From: Nicola Swann 
Sent: 19 May 2021 14:15
To: Planning.Responses <Planning.Responses@arun.gov.uk>
Subject: Pagham responses

P/69/21/CLP - To construct a temporary access haul road across land attributed to public open space, from Pagham Road, via the Pagham United Reform Church car park. Access via the car park into the field will be created.

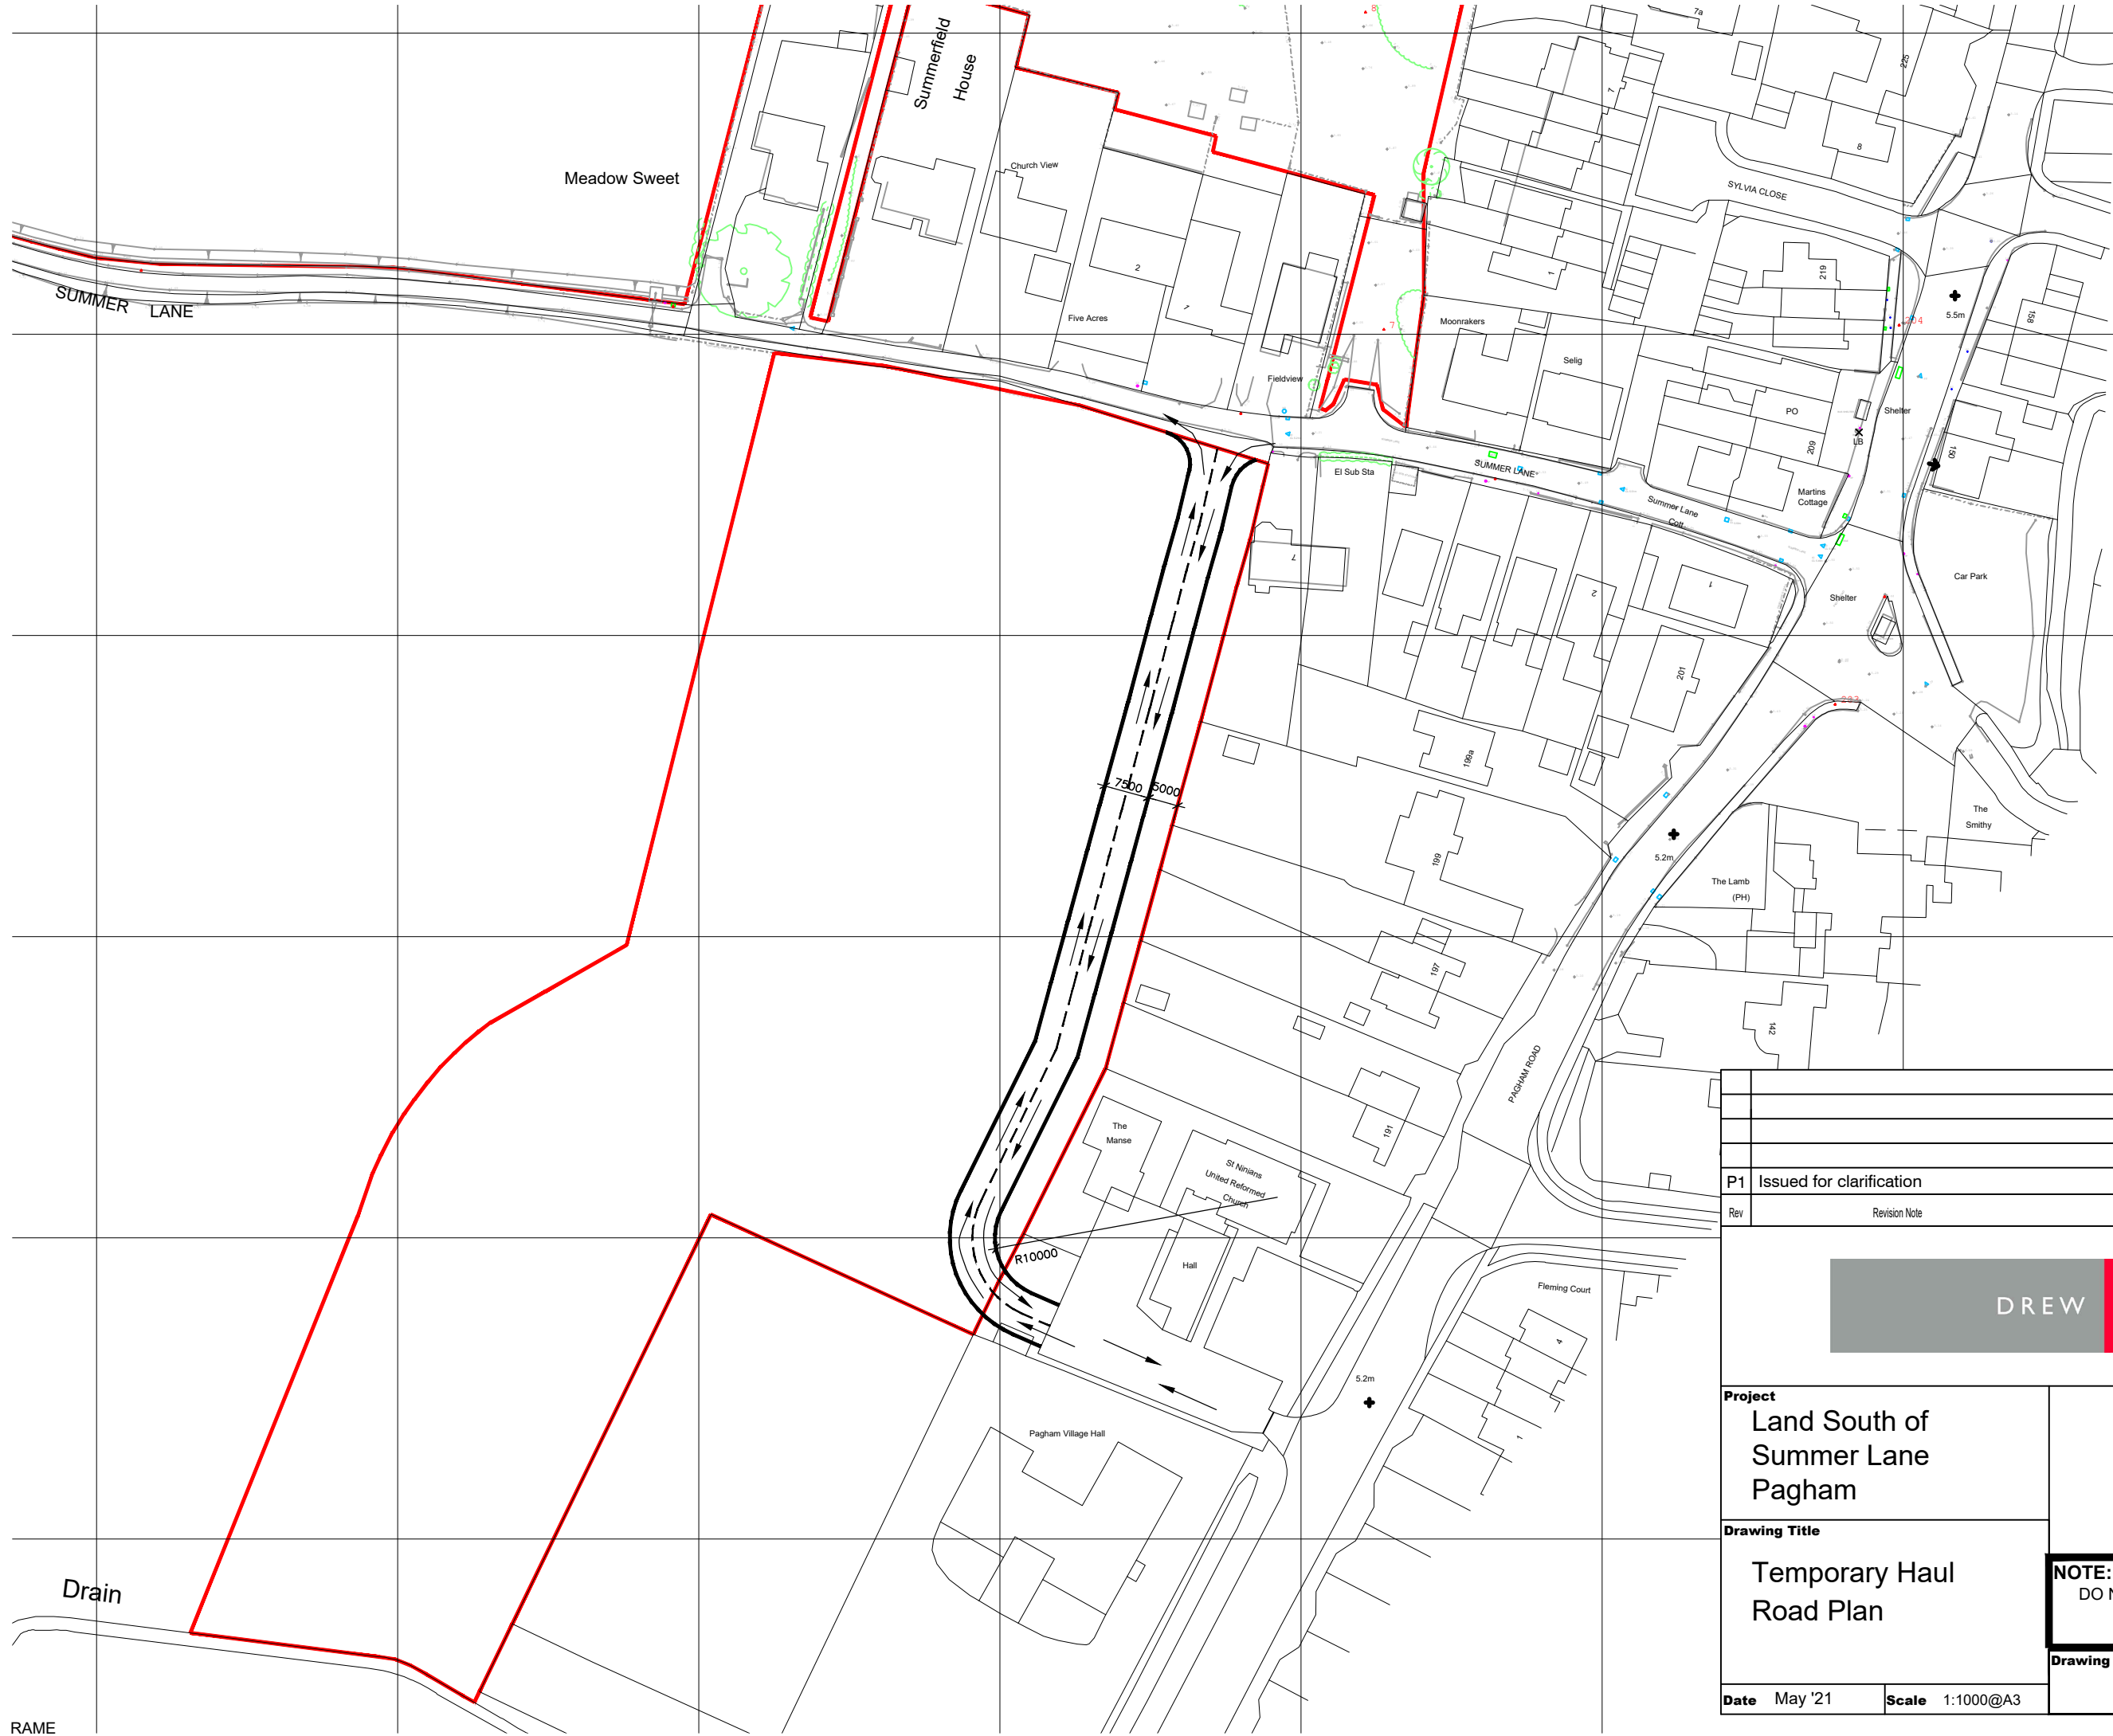
Whilst members could see that an access through the carpark might help the plight of residents of Summer Lane, the Group was concerned by this application and the Clerk submits an OBJECTION on behalf of the Parish Council for the following reasons:

- St Ninian's Church is hired out to community groups during the day and in the evenings, including groups involving children and those from vulnerable groups. Members were concerned that there were safety implications for users accessing the Church whilst the road was being used.

- There would inevitably be an impact on local roads if the carpark were not available to users of the Hall.
- There is a pedestrian access to the Parish Hall next to the entrance to the St Ninian's car park. This access is used by local residents who use the Parish Hall and access on foot. This again includes children (a preschool is located at the Parish Hall) and vulnerable groups. Serious concerns were raised over safety of those using the pedestrian entrance.

- Concerns were raised over the likelihood of dust and mess being created by the road during dry months. This was unneighbourly and could pose a threat to residents' health.
